**13 Blackwood Place, Bodicote, Banbury, OX15
4BD**

23/03116/NMA

Proposal: The omission of two chimney stacks and insertion of a metal flue. Rooflights at the rear of the property in a different position. A window instead of a patio door at the rear of the property (proposed as non-material amendment to 21/00026/F)

PROPOSED SOUTH WEST ELEVATION 1:50

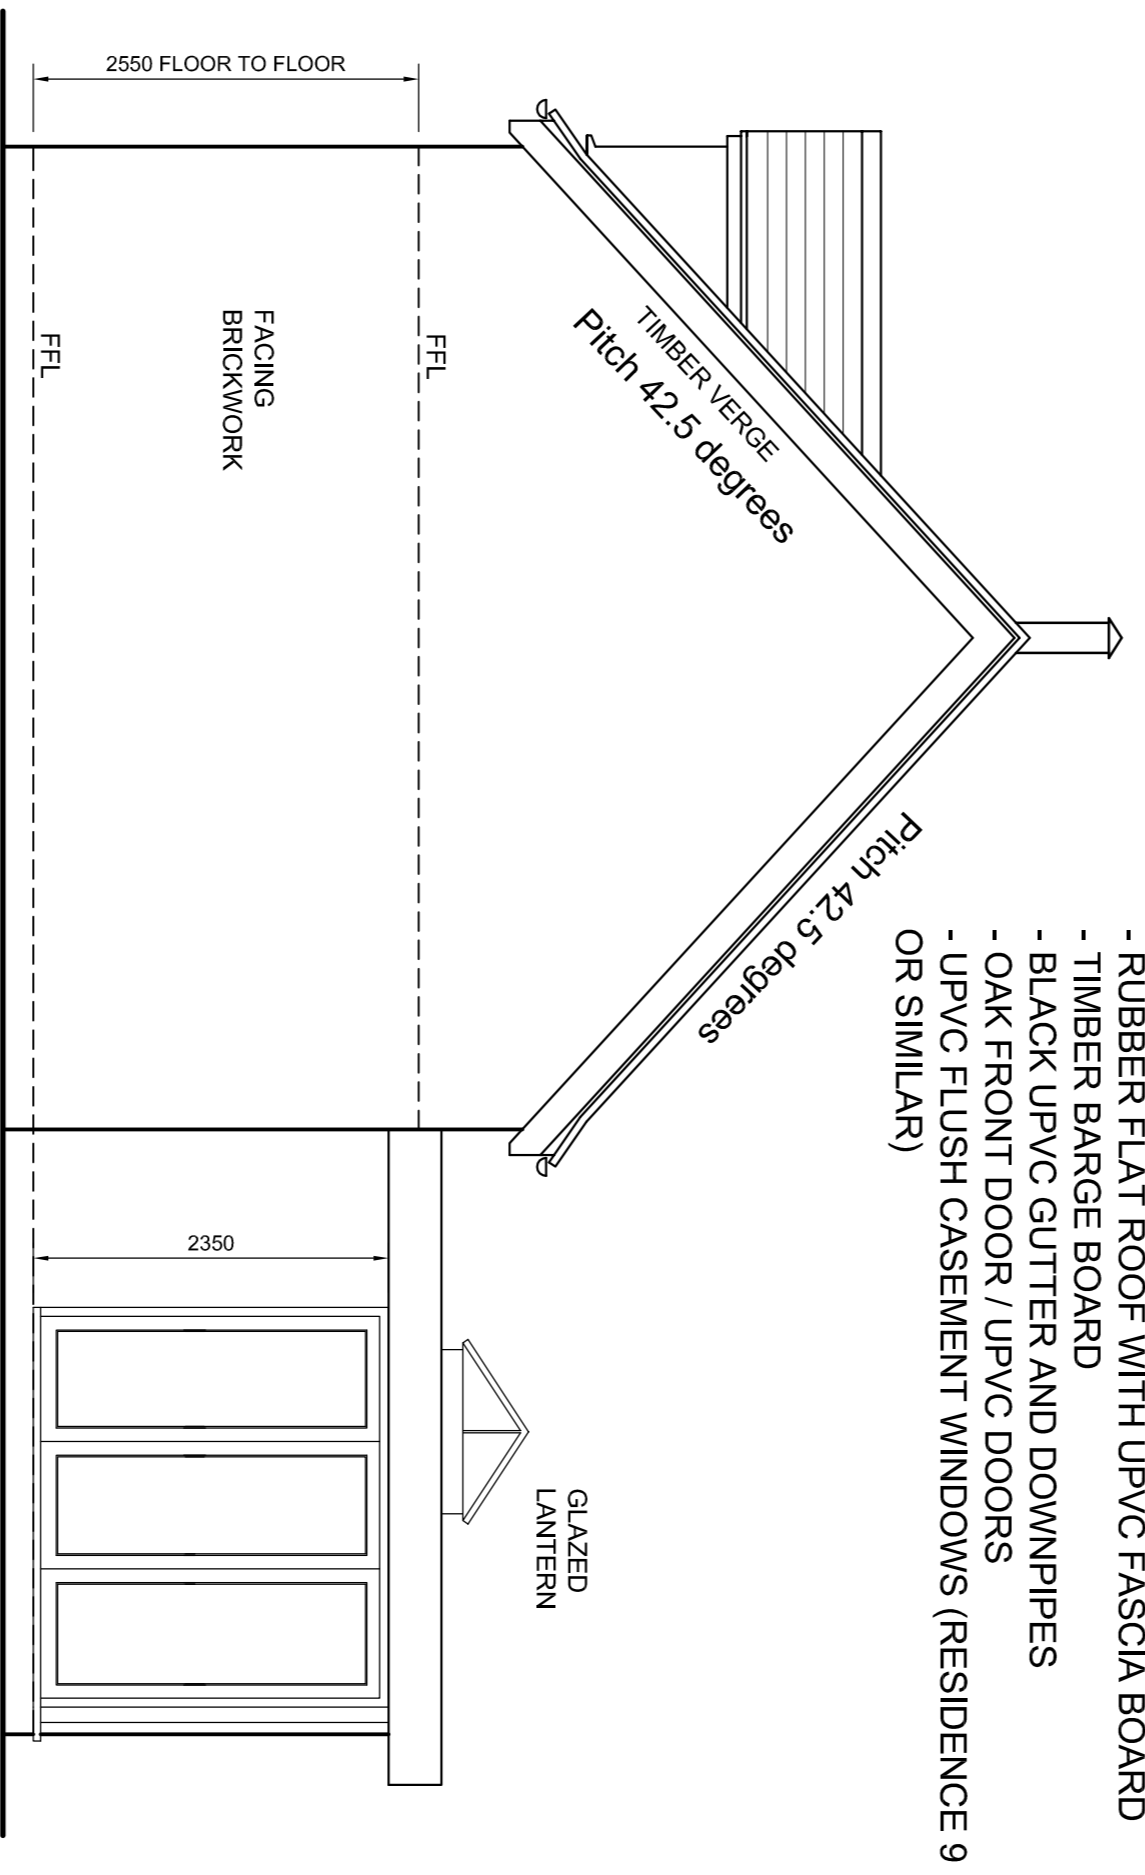
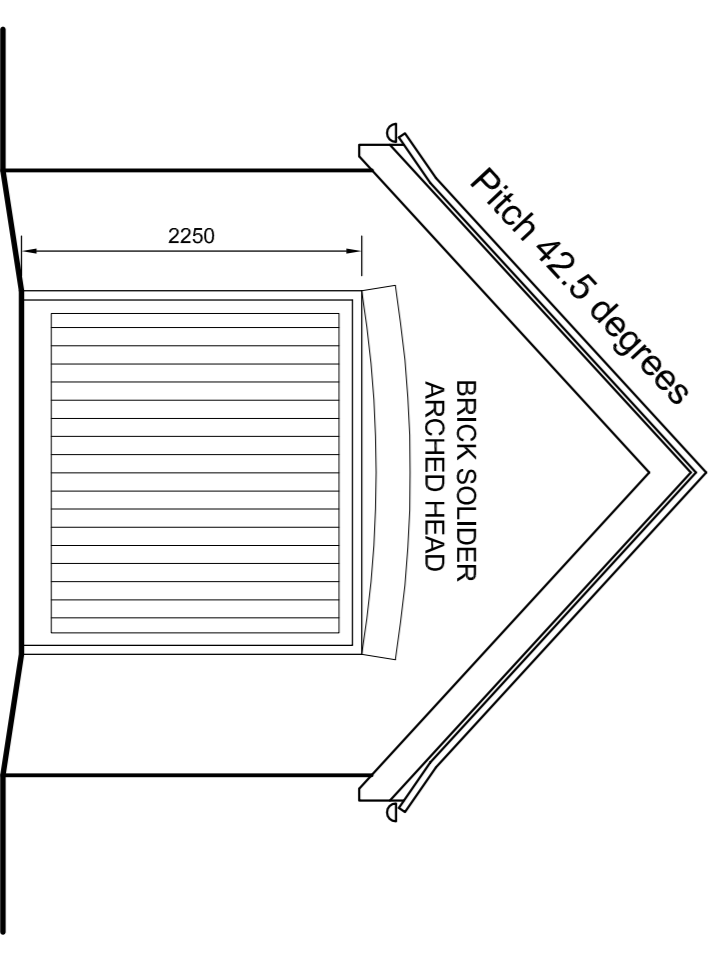
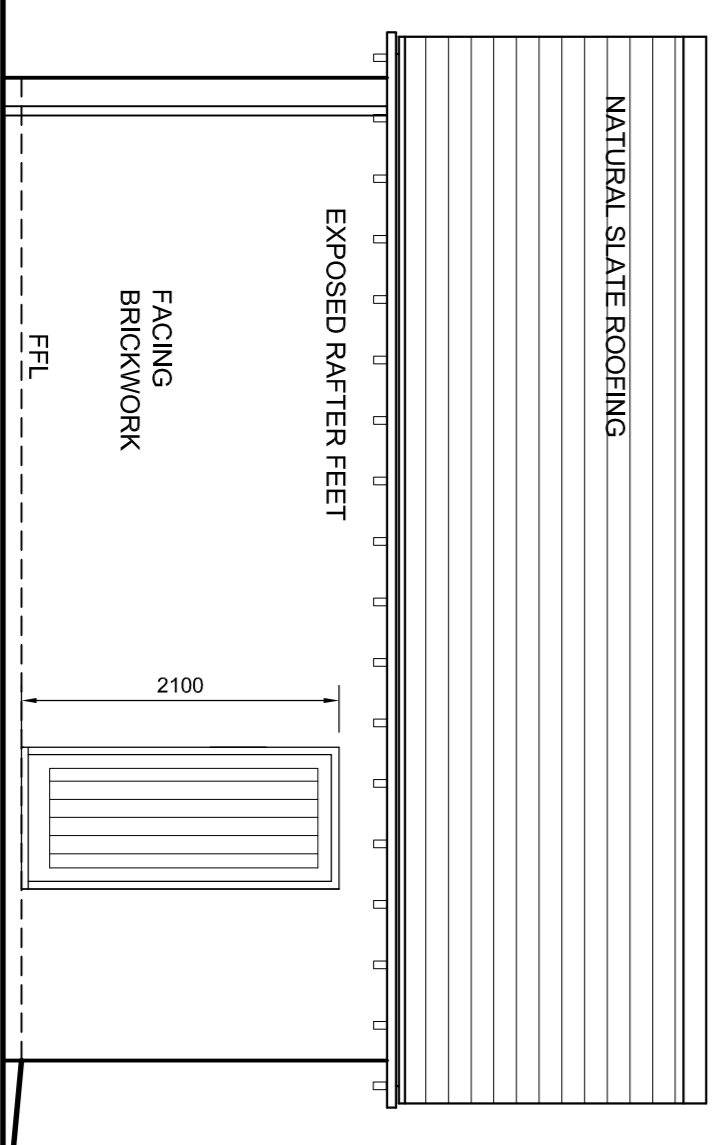
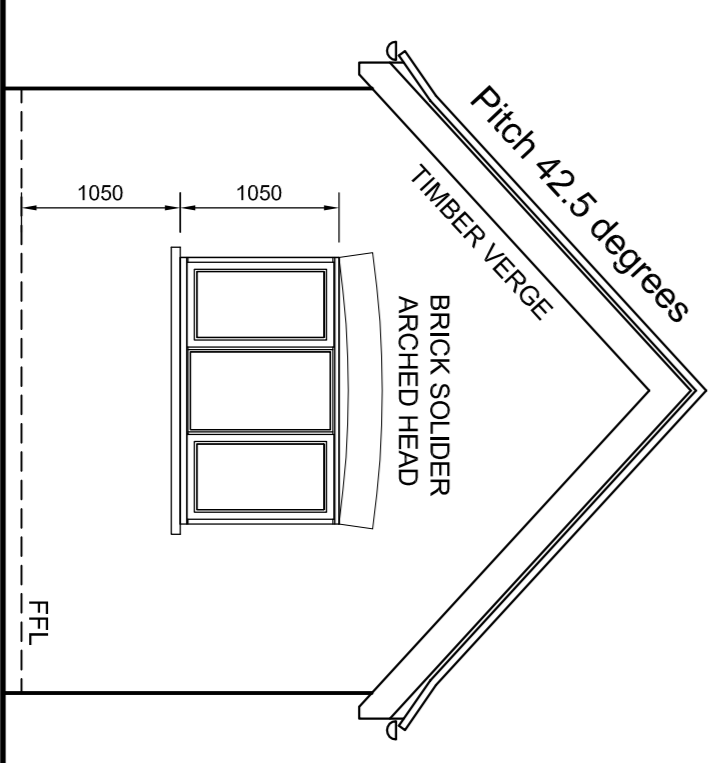
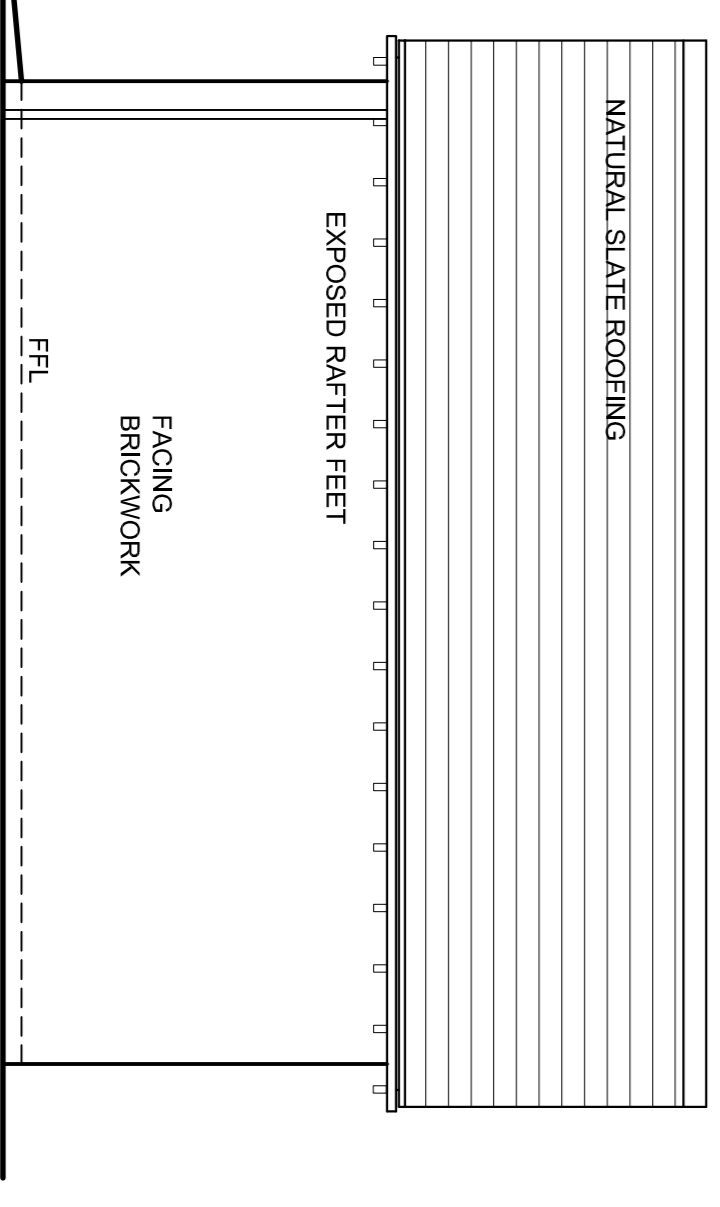
- 2.1. The application seeks consent for changes to planning permission ref. 21/00026/F, specifically to make the following changes:
 - The omission of two chimney stacks and insertion of a metal flue
 - The reposition of the proposed rooflights within the rear elevation.
 - Replacement of a patio door within the rear elevation

- 5.4. The proposed changes would have a visual impact, the most visible changes being the replacement of the chimney stacks with the insertion of the metal flue and the repositioning of the roof lights. The omission of the chimneys would result in some diminution in quality of the development approved under application reference (21/00026/F).

- 5.5. Overall, however, the proposed changes would result in a similar character of development to the previously approved and would not significantly affect the character of the development – particularly given the site’s location outside of a Conservation Area and with the tree screening from the highway, or raise any new issues in relation to the visual and residential amenity.

- 6.1. The proposal is therefore considered to be non-material and the application is therefore recommended for approval.

In accordance with drawing No “03 REV A”
